Consultation Response from: Planning Policy Group		
Address: Land adjacent 67 Chapelgate Scholes Holmfirth		
Proposal: 2022/92406 Erection of 10 affordable dwellings and associated works including resident play zone.		
Date Responded: 30/11/2022	Responding Officer: Steven Wright	Responding Ref:
The Local Plan was adopted on 27th February 2019. The Holme Valley Neighbourhood Development Plan (HVNDP) was made in December 2021 and forms part of the Development Plan for Kirklees. The following response relates to specific policies which are particularly relevant to the proposal. The Development Plan should be considered as a whole, so other policies not mentioned here may also apply. The site lies within the Green Belt as designated on the Kirklees Local Plan. NPPF paragraph 149 states that a local planning authority should regard the construction of new buildings as inappropriate in the Green Belt unless the building falls within one of the exceptions listed in the paragraph, the relevant one in this case being criterion f) which allows for limited affordable housing for local community needs under policies set out in the development plan, including policies for rural exception sites.

Fencing and Wall Detail

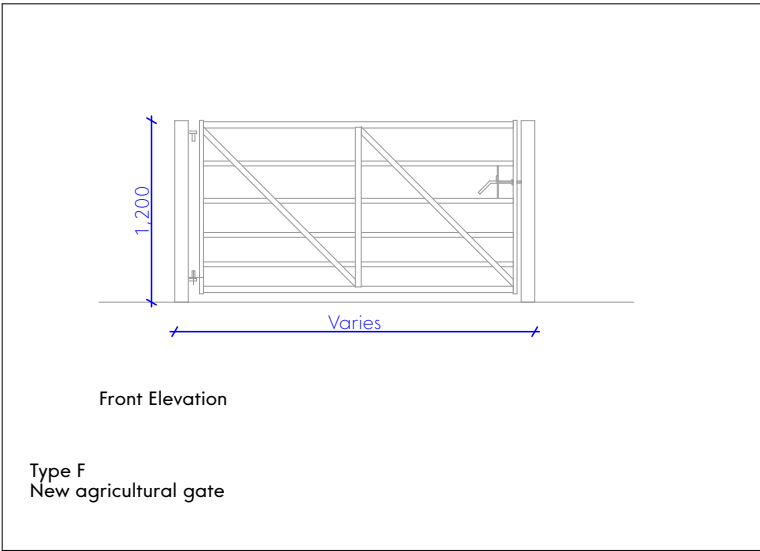
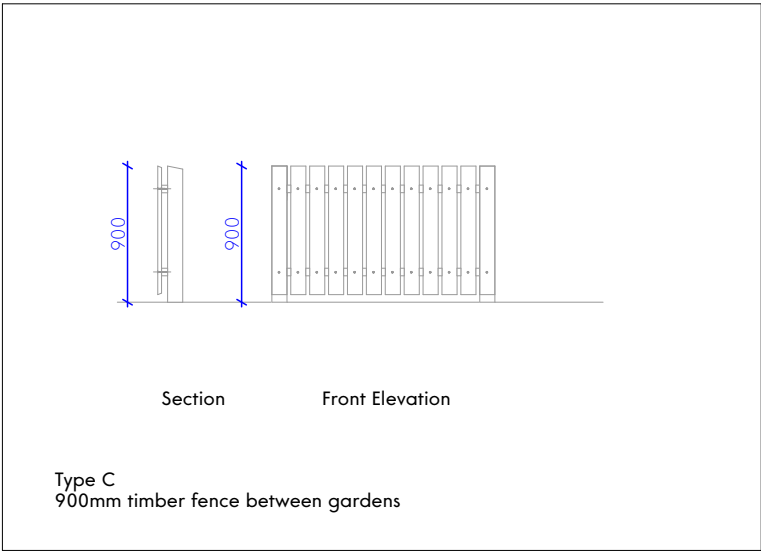
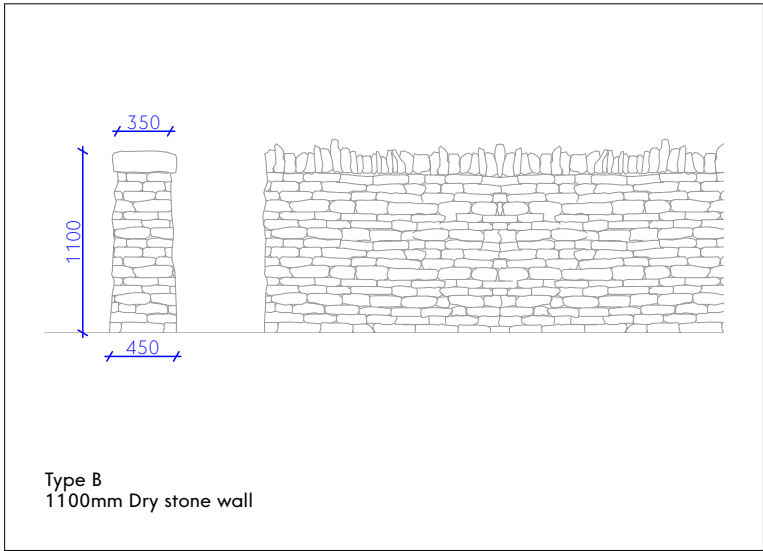
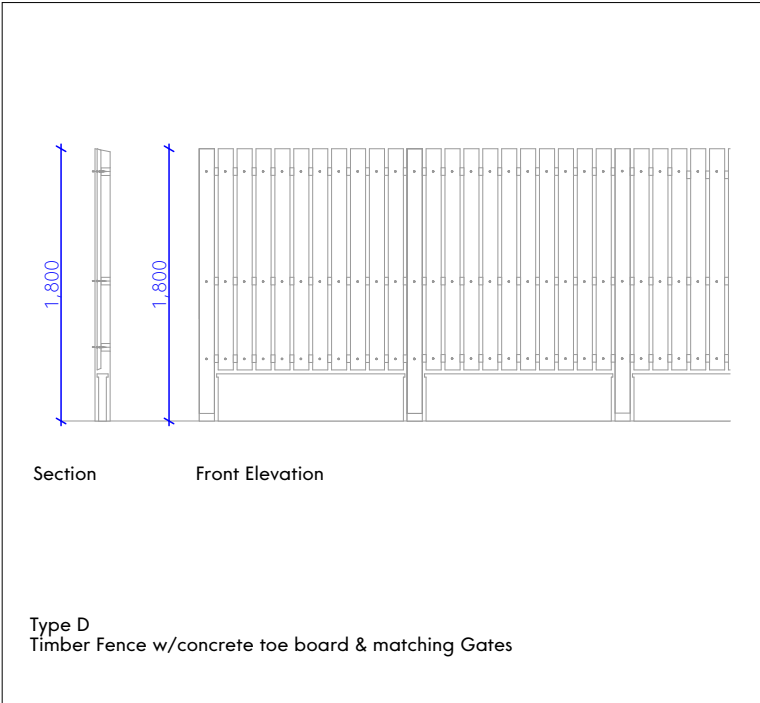
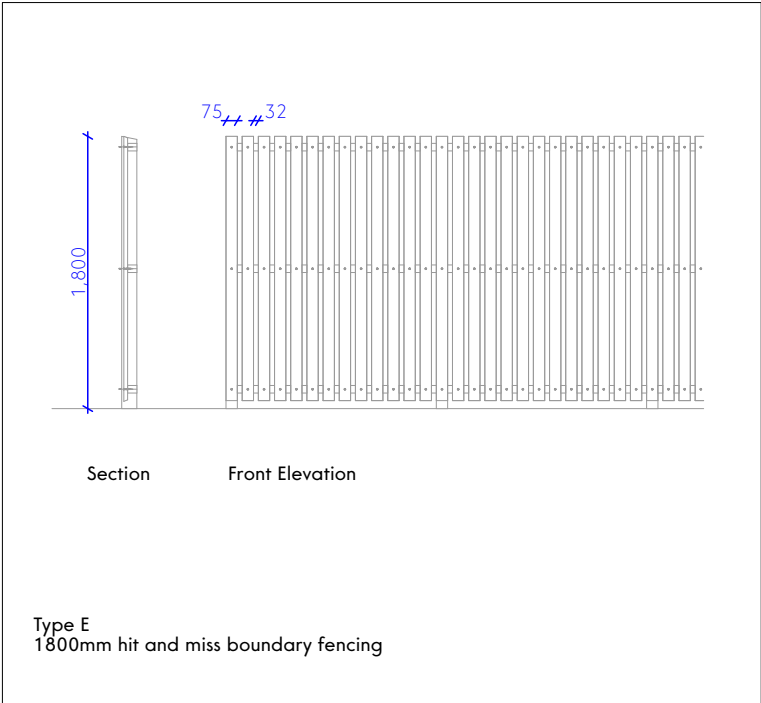
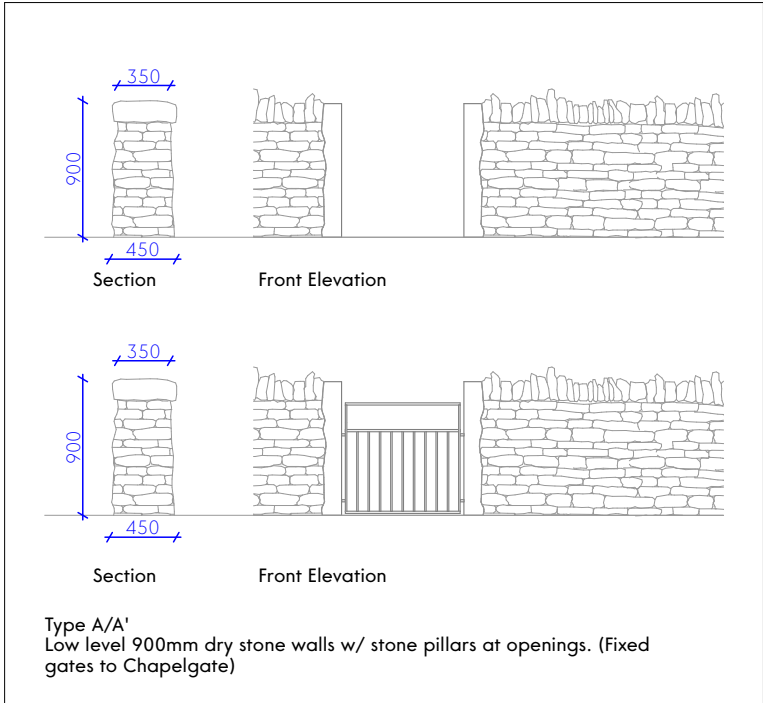
As well as the communal areas there is private amenity space proposed between the blocks and the highway and to both sides of block A. While the provision of 10 individual gardens would have further impact on openness through the fragmentation of the site, gardens of this design are in keeping with the area and private amenity space is to be expected. As set out in Policy 1 of the Holme Valley

Neighbourhood Plan, boundary treatments should be sensitive to the relevant Landscape Character Area, in this case Landscape Character Area LCA8 (Settled Slopes of the Holme Valley).
